Rezoning Transportation Analysis

Petition Number: 2023-042

Revision Log:	Date	Description
	7-26-23	First Review (PM)
	8-23-23	Second Review (PDM)
	11-27-23	Third Review (JP)
	12-20-23	Fourth Review (JP)
	3-20-24	Fifth Review (JP)

RZ - 200

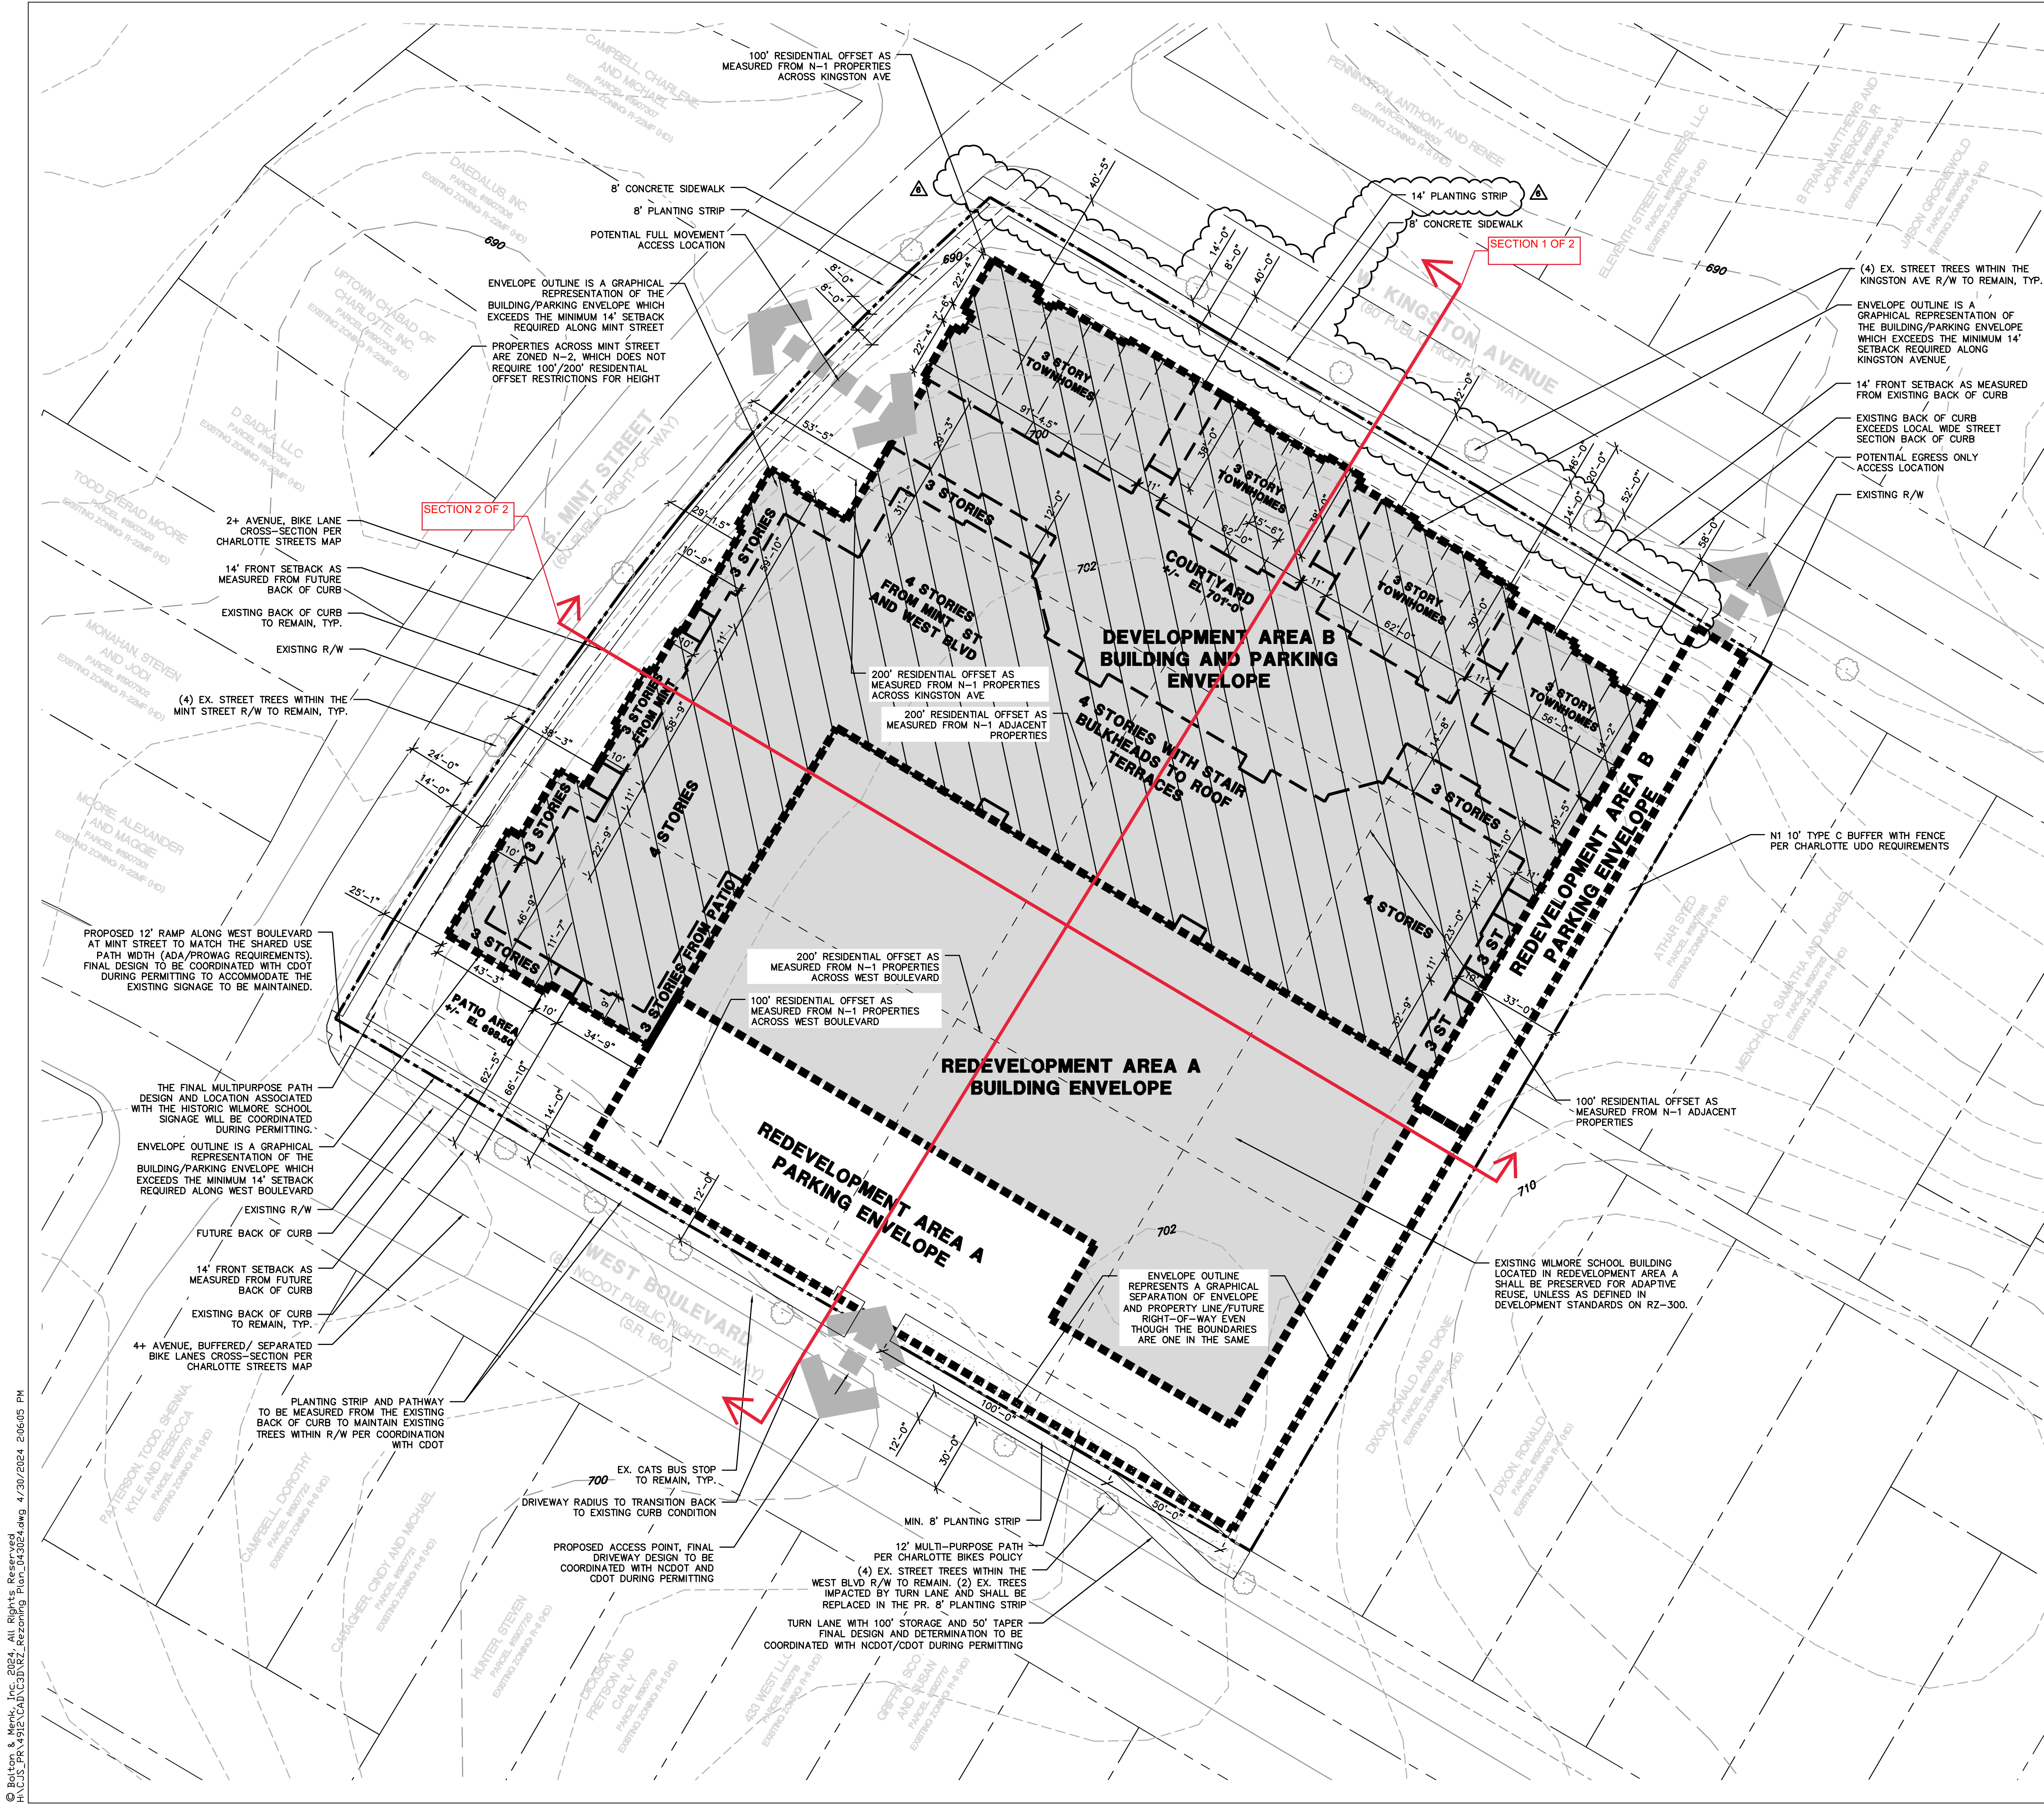
- b. **South Mint Street:** Future back of curb is in its existing location

- c. **West Kingston Avenue:** Future back of curb is in its existing location

Label and dimension the future curb and gutter location from the centerline for each road on the site plan.

7. ~~Outstanding Comment from 7.26.23:~~ Per coordination with NCDOT, the site access on West Boulevard needs to be right in ONLY with a right turn lane.

~~Clarifying Comment 12.20.23:~~ Although this is an existing driveway, NCDOT has the authority to remove or limit access. Add statement to callout and conditional note that approval of West Boulevard driveway will be coordinated during permitting.

9. **New Comment 3.20.24:** Show a proposed 12' ramp to match the shared use path width (ADA/PROWAG requirement).
